# CITY OF ALBUQUERQUE

**Planning Department  
Transportation Development Services Section**

Re: Certification Submittal for Final Building Certificate of Occupancy for  
Gonzales Bus.(Lot 4, Volcano Business Park, phase I), [G-10 / D29H]  
3020 Todos Santos St. NW  
Architect's Stamp Dated 02/06/05

Re: Certification Submittal for Final Building Certificate of Occupancy for  
Gonzales Bus. Maint. (Lot 4, Volcano Business Park, phase i),  
G-10 / D29H]  
3020 Todos Santos St. NW  
Architect's Stamp Dated 01/26/05

SITE DEVELOPMENT PLAN FOR BUILDING PERMIT

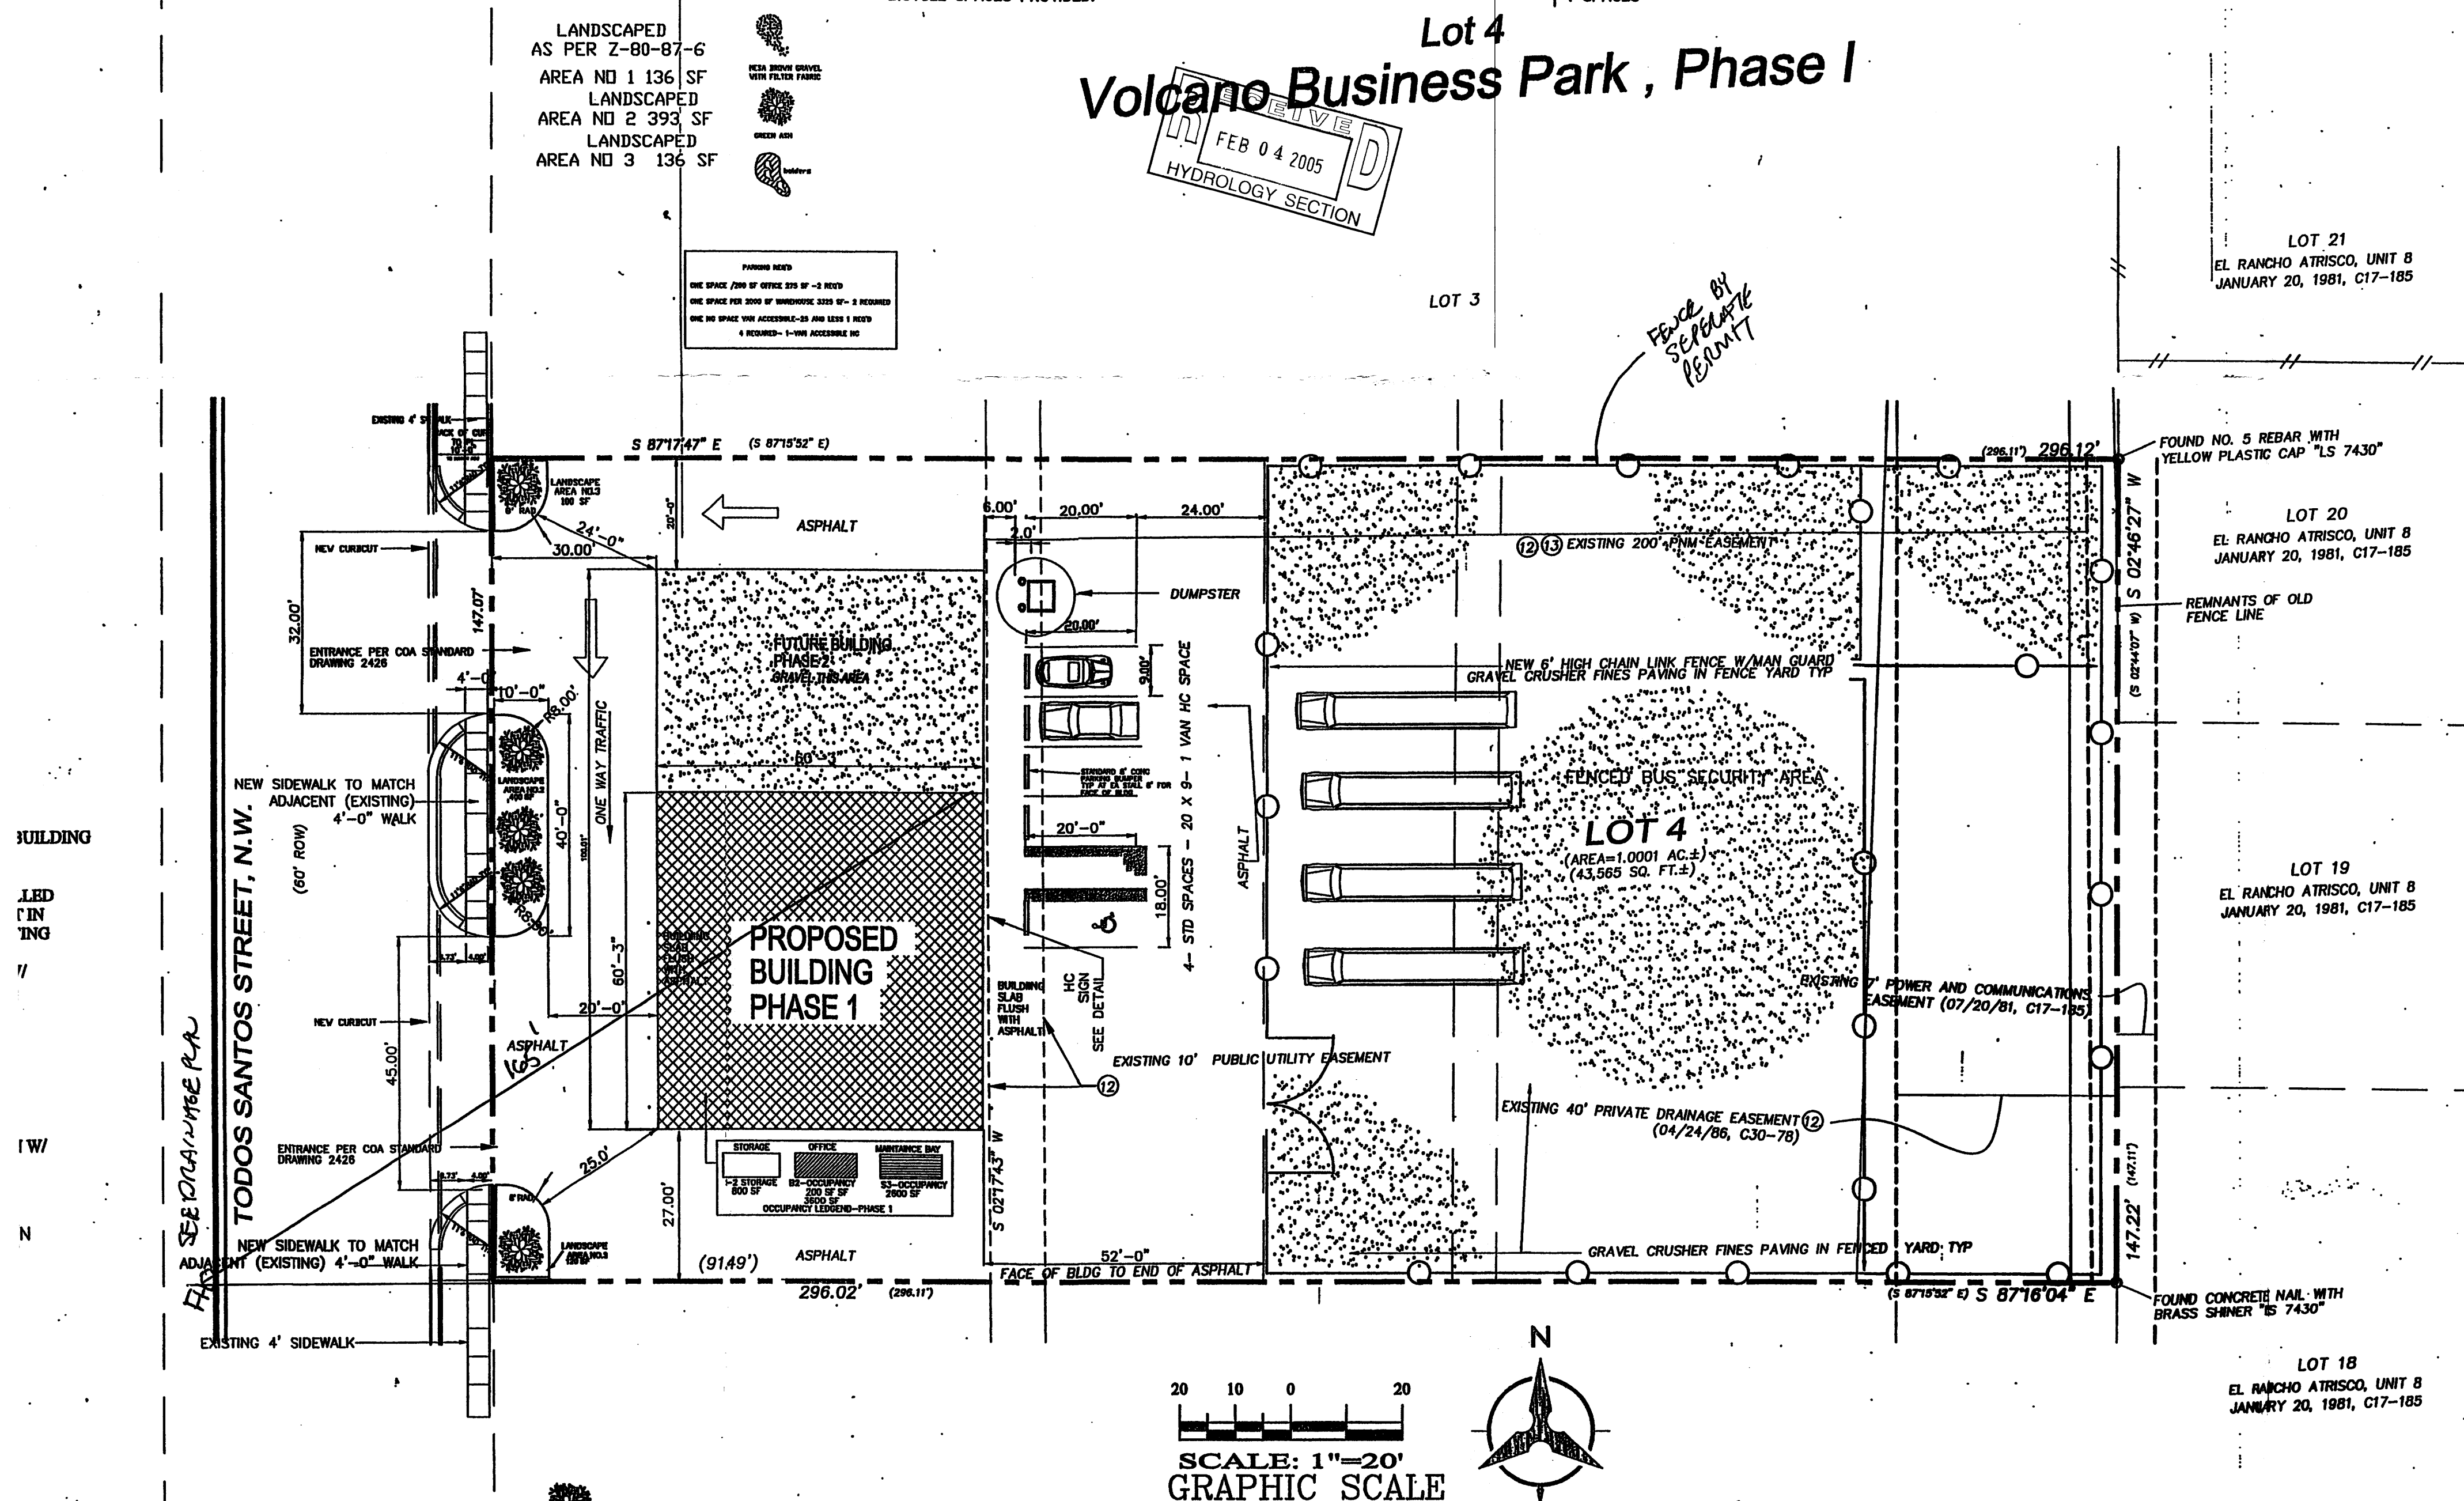
The approved TCL (or DRB Site Plan) needs to be submitted with the letter of certification (The words 'substantial compliance' needs to be part of your verbiage for certification) for Final C.O. and needs to be the exact copy of the approved TCL in the plan set approved for building permit. This will be the latest edition, which may have redlined comments, initialed and dated by the designer-of-record.

As per your request, I am submitting this letter stating that this project is in substantial compliance for Final Certificate of Occupancy and that all transportation department rules and regulations were followed as related to the above-mentioned facility and the approved DRB site plan. Please find attached a copy of the approved TCL (DRB Site Plan) that is in the approved plan set for building permit. This latest edition with any and all redlined comments are initialed and dated by me as Architect of Record. Also attached is the fully completed Drainage Information Sheet by others.

Sheet Title	GRADING & DRAINAGE PLAN
Drawn By:	H Hood & BUM
Checked By:	BUM

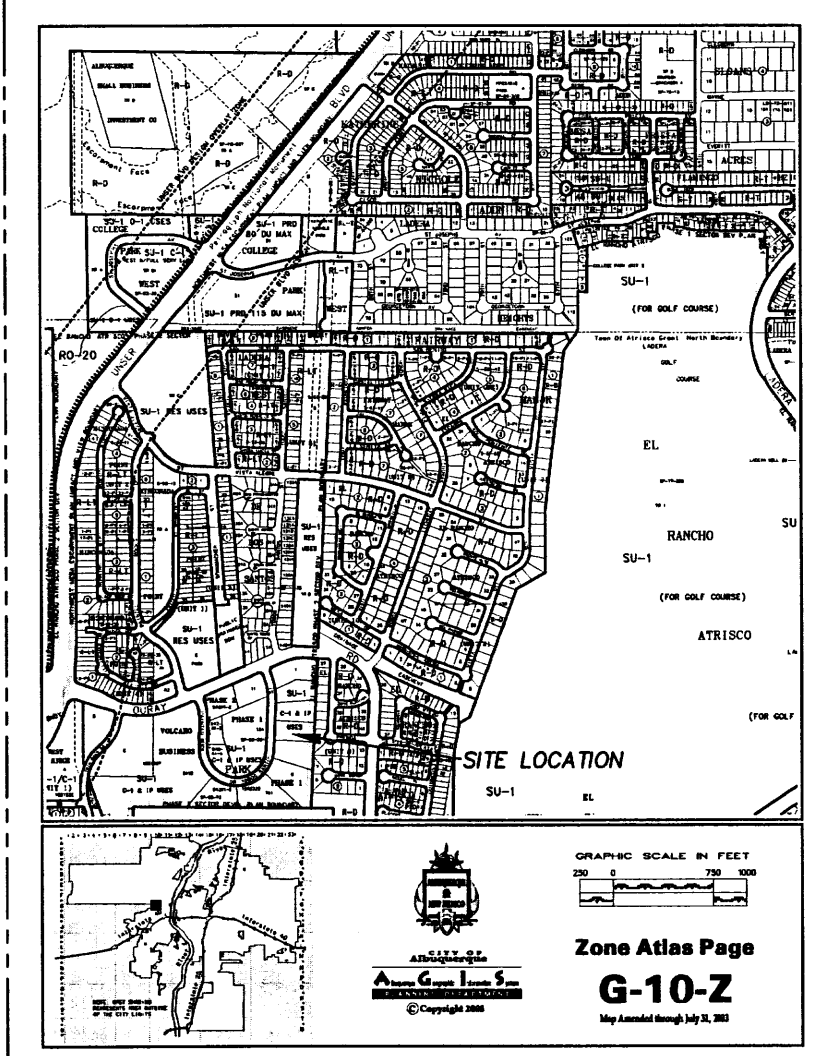
- Please better define the limits of pavement, gravel and landscaping per the DRB approved Site Development Plan.
- There are keynotes but no description of what they indicate.
- What are the slope and treatment of the channel side slopes? How will your runoff get to the channel without headcutting along the north property line?
